Peter McManus - Submission regarding Applic no MP07_0158 MOD 3 Syd Uni Abercrombie precinct

Ref Modification Request for the University of Sydney Abercrombie Precinct Redevelopment

Application no: MP07_0158 MOD 3

Ground Floor Plan
1:200@A1
11.10.13
4001_DA02-D

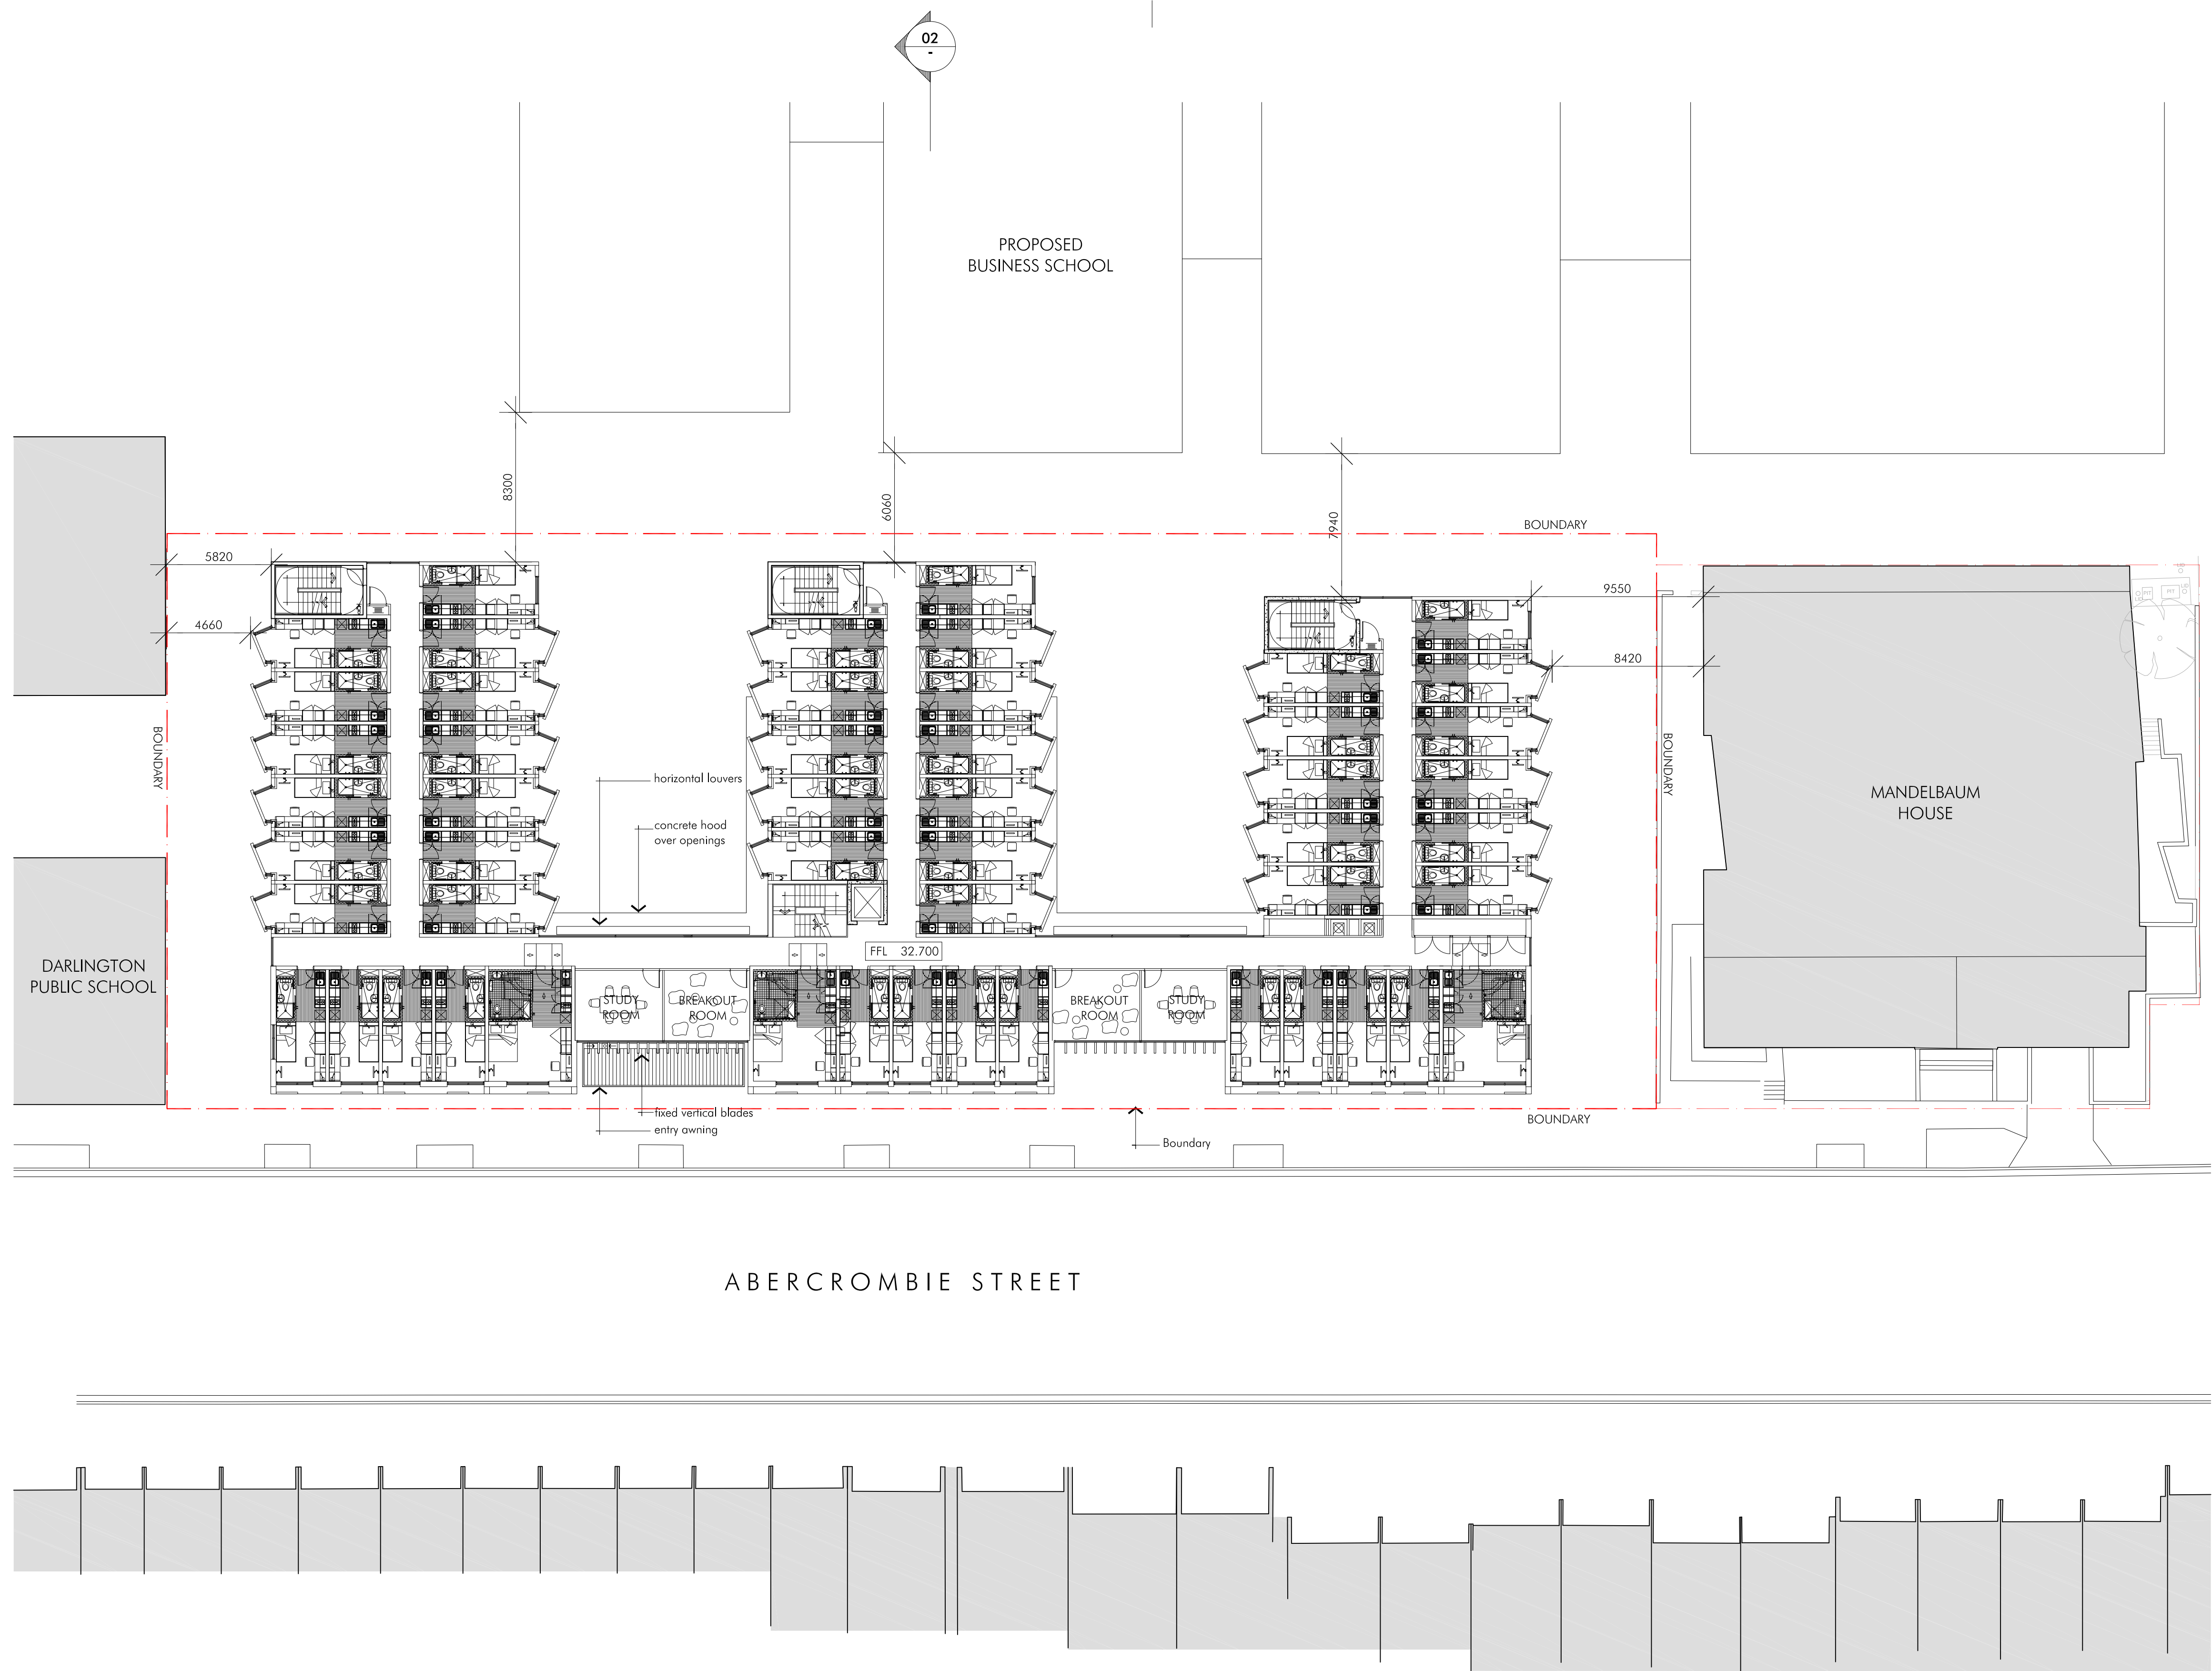
The student accommodation building should be set back from Abercrombie Street, in line with Mandelbaum House

Extensive vegetation and trees should be planted in front of the building on Abercrombie Street to preserve heritage streetscape
